**Proposed Roundabout Access To Graven Hill
And Wretchwick Green, London Road, Bicester**

21/01420/NMA

2. DESCRIPTION OF PROPOSED AMENDMENT(S)

**A41 PIONEER ROUNDABOUT
DRAINAGE LAYOUT**

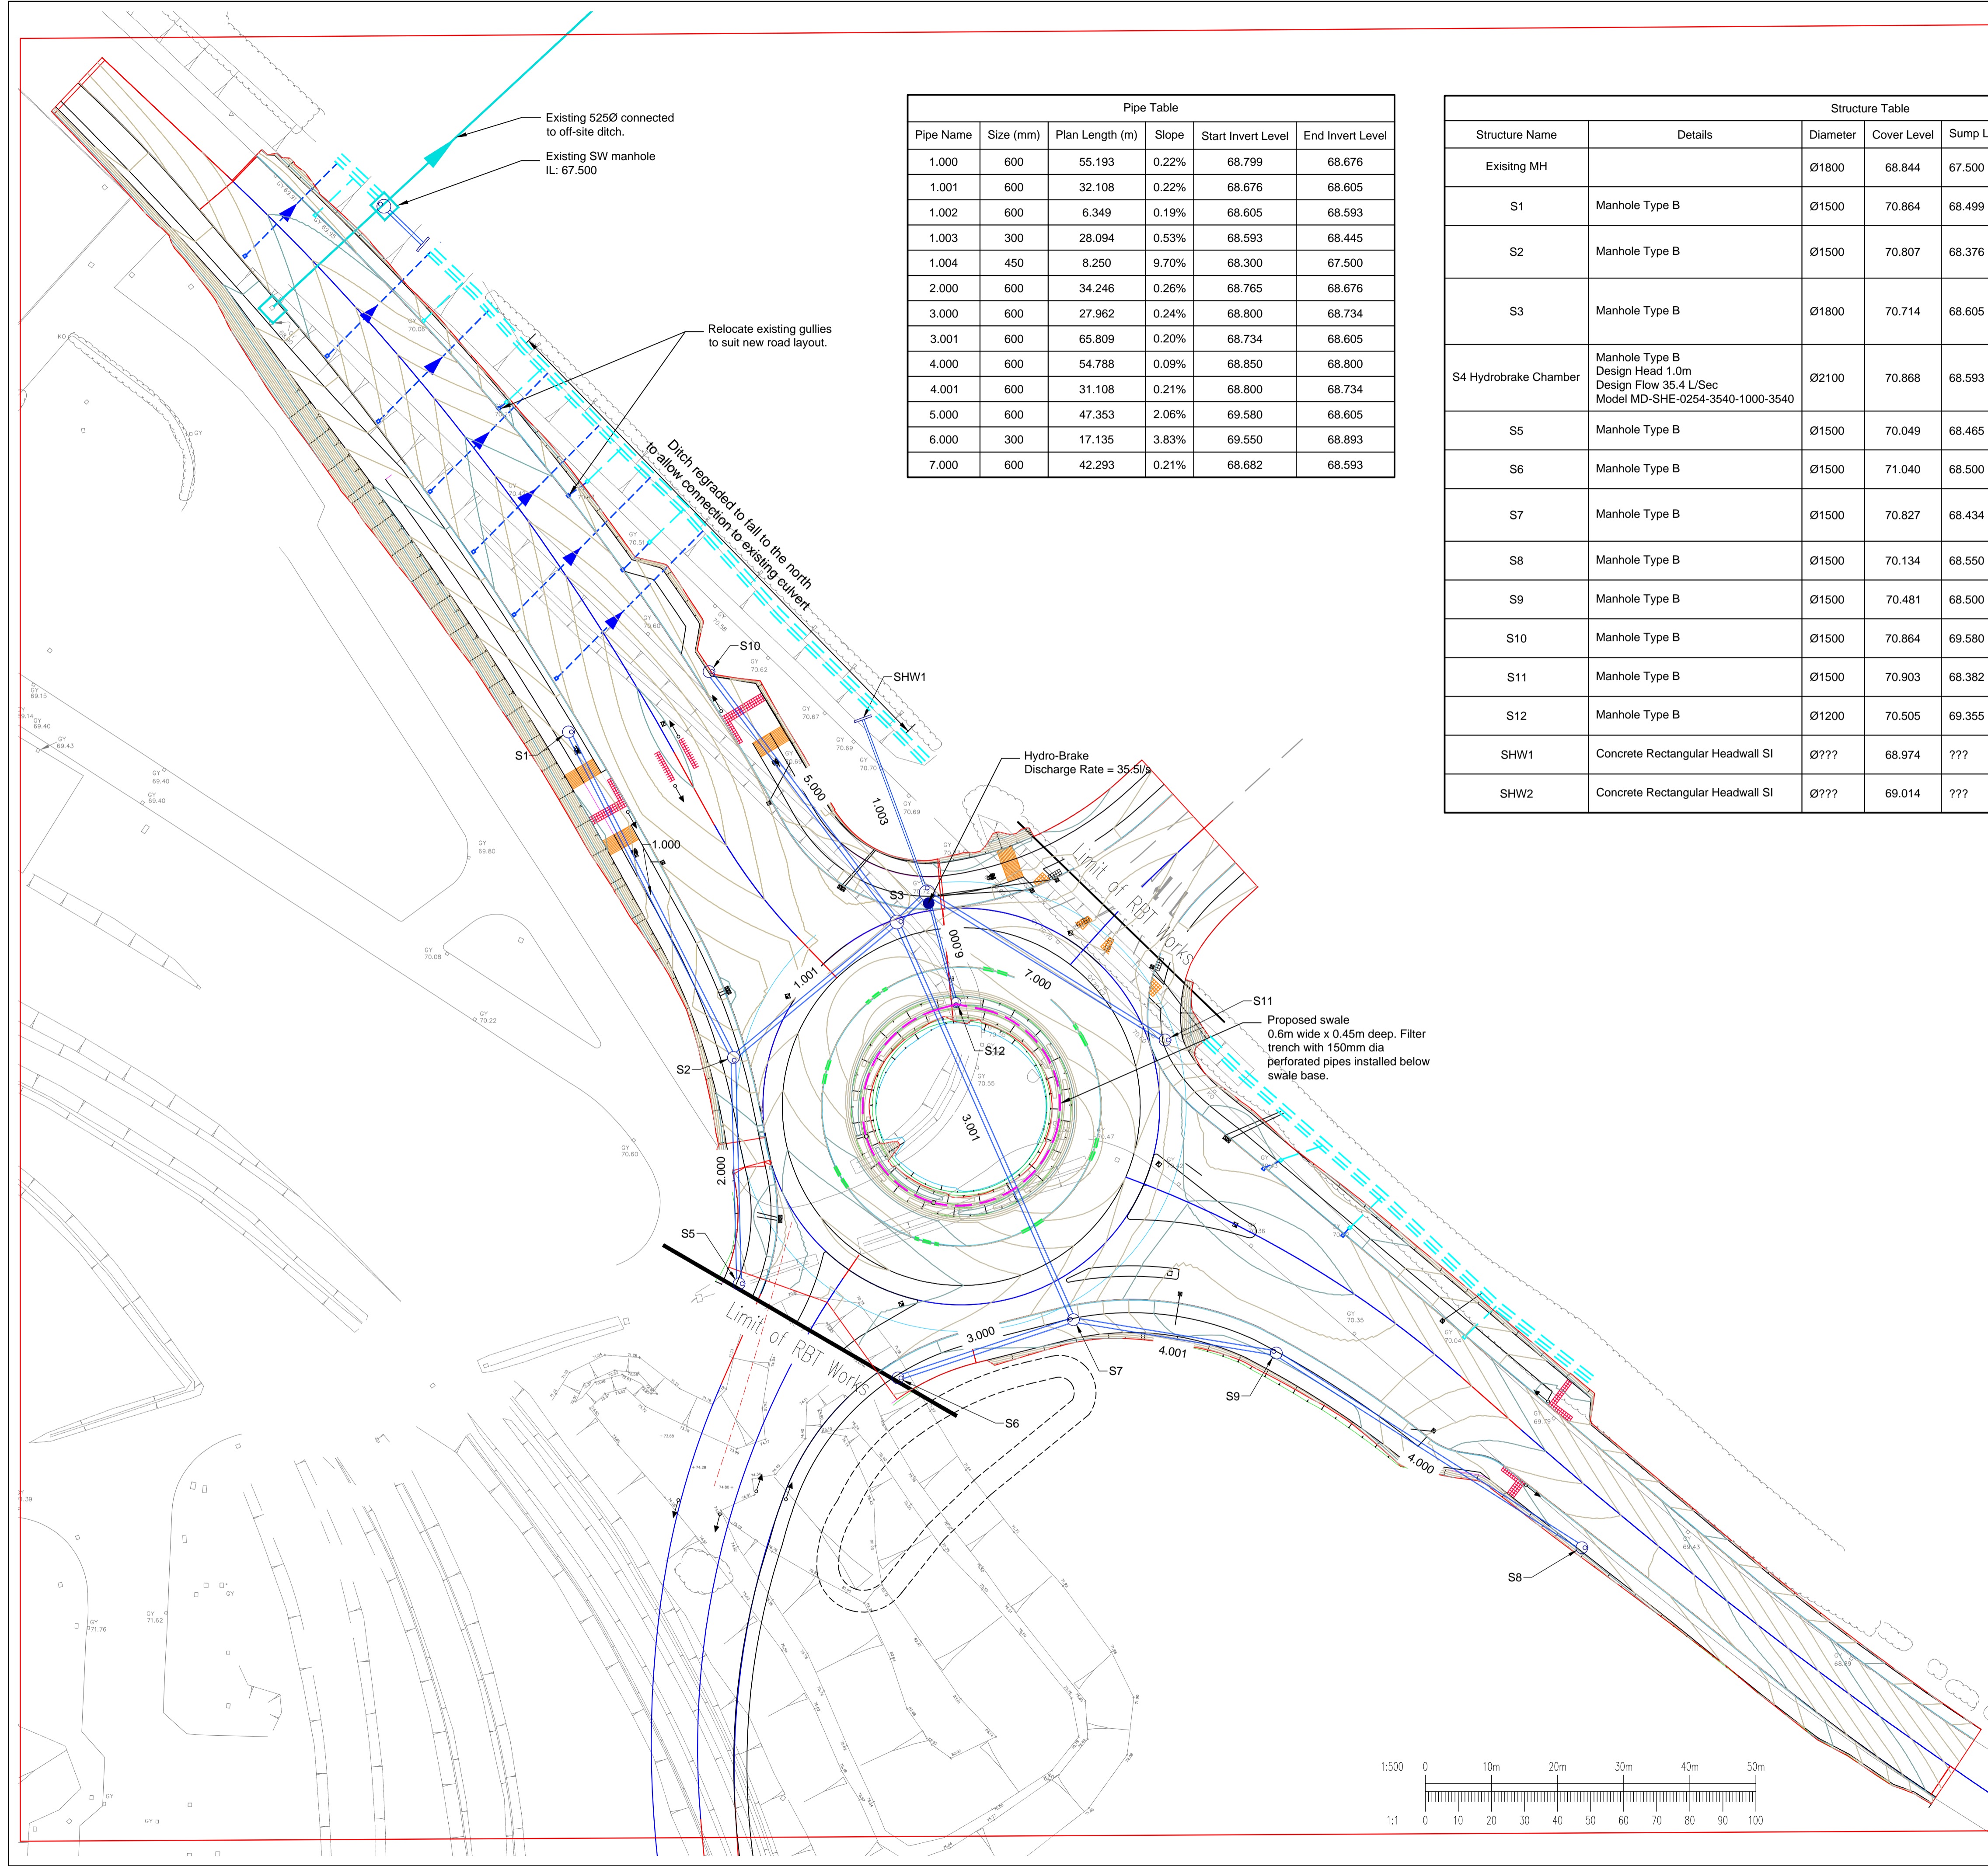
- **Drainage:** The previous drainage strategy included surface water attenuation within the central island of the roundabout. The attenuation has been removed and the proposals now include:

- I. A swale within the central island to allow conveyance of surface water from the circulatory carriageway.
 - II. Oversized pipes (600mm diameter) to provide below ground storage in high rainfall events.

- III. Provision of a hydrobrake to control surface water discharge to the ditch north of the A41 at agreed rates with Oxfordshire County Council.
